Your ref: 3/2024/0996
Our ref: DC/24/3050v2
Date: 14-APR-25

Location: 98 Rochester Road and land adj 94 Ribchester Road Clayton-Le-Dale BB1 9HQ
Proposal: Approval of details reserved by conditions 9 (SW drainage), 12 (drainage scheme)

Further to our review of the submitted documents, Drawing Proposed Drainage Layout, Dated December 2024, United Utilities recommends that conditions 9 and 12 are **not discharged**. This is because:

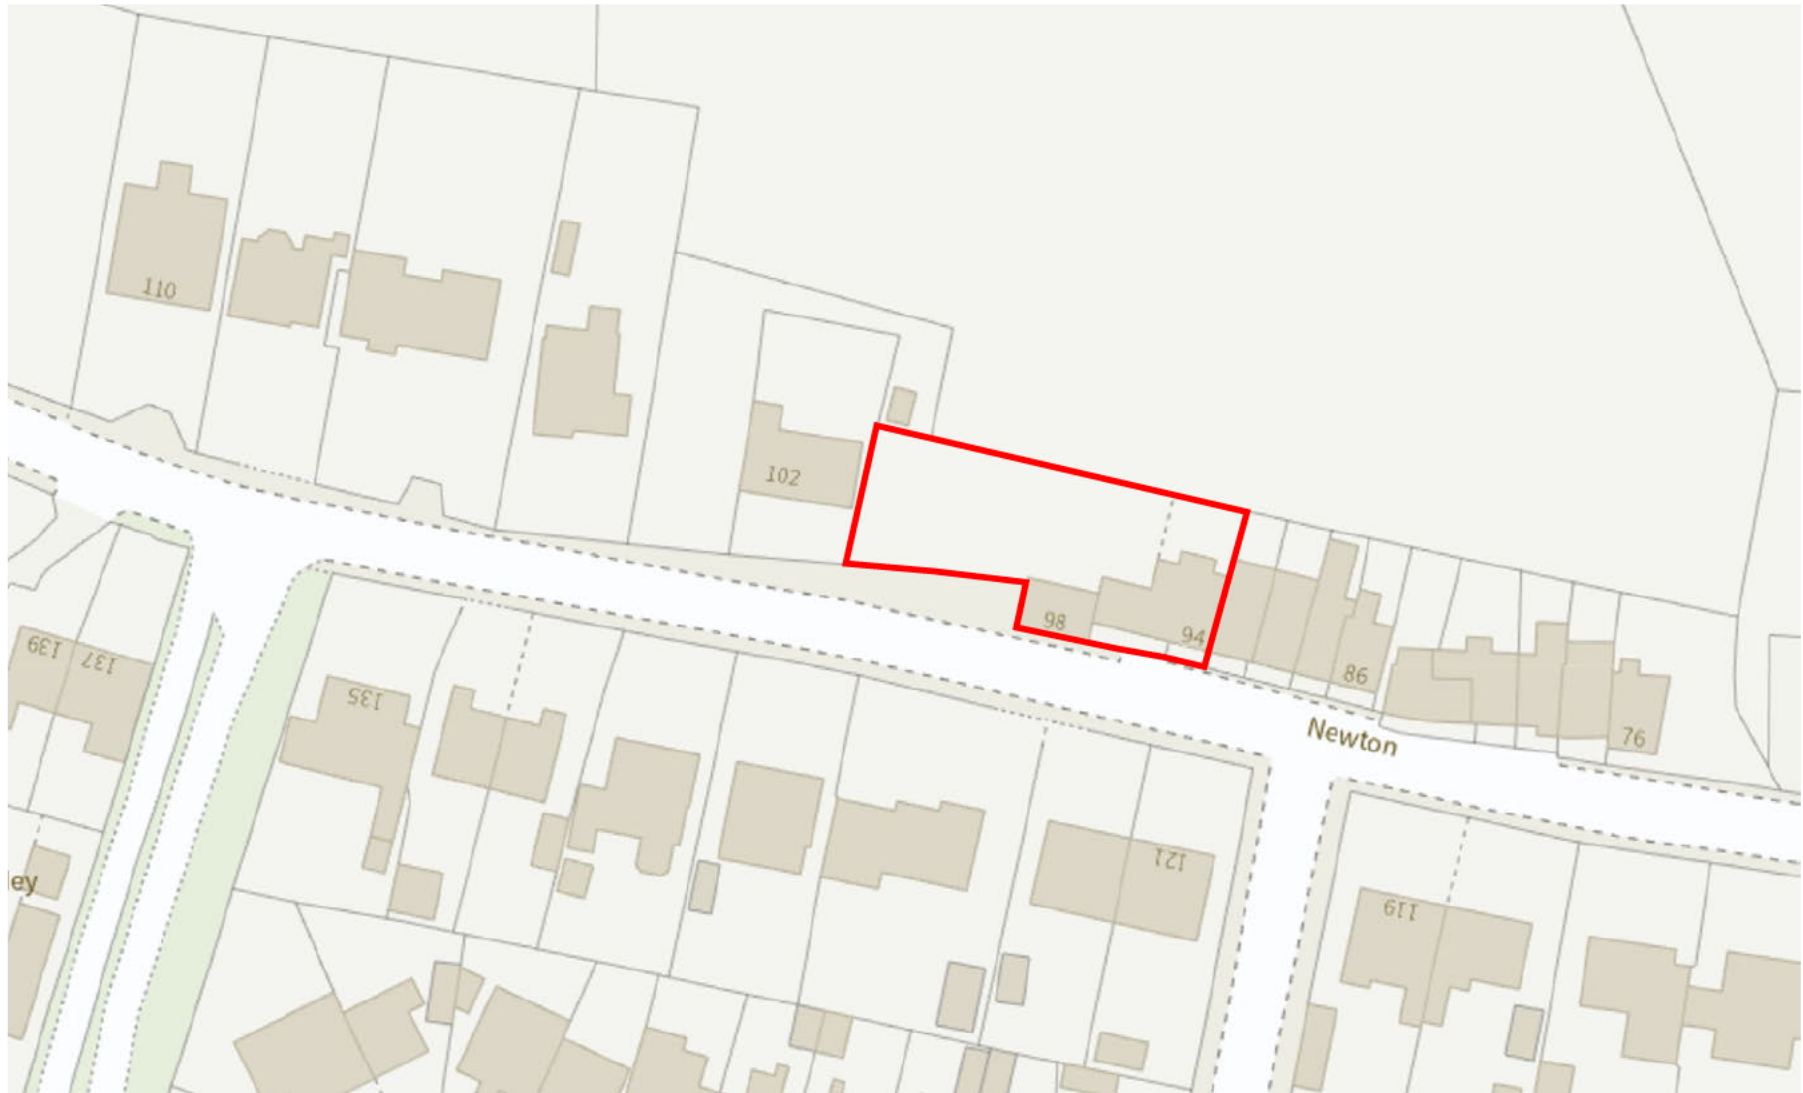
- It is unclear how the connection is being made with the public wastewater network. We require a detailed drainage plan; clearly demonstrating how the scheme would connect to the public sewer. Noting that this is an application to discharge drainage conditions, we would expect the invert levels and cover levels to be included on the drainage plan.
- The sewer shown on our records is being assumed to be a combined sewer. The asset maps indicate it is a foul only sewer. We require evidence i.e. a drainage survey, to confirm that the foul sewer we have on our records is in fact a public combined sewer.
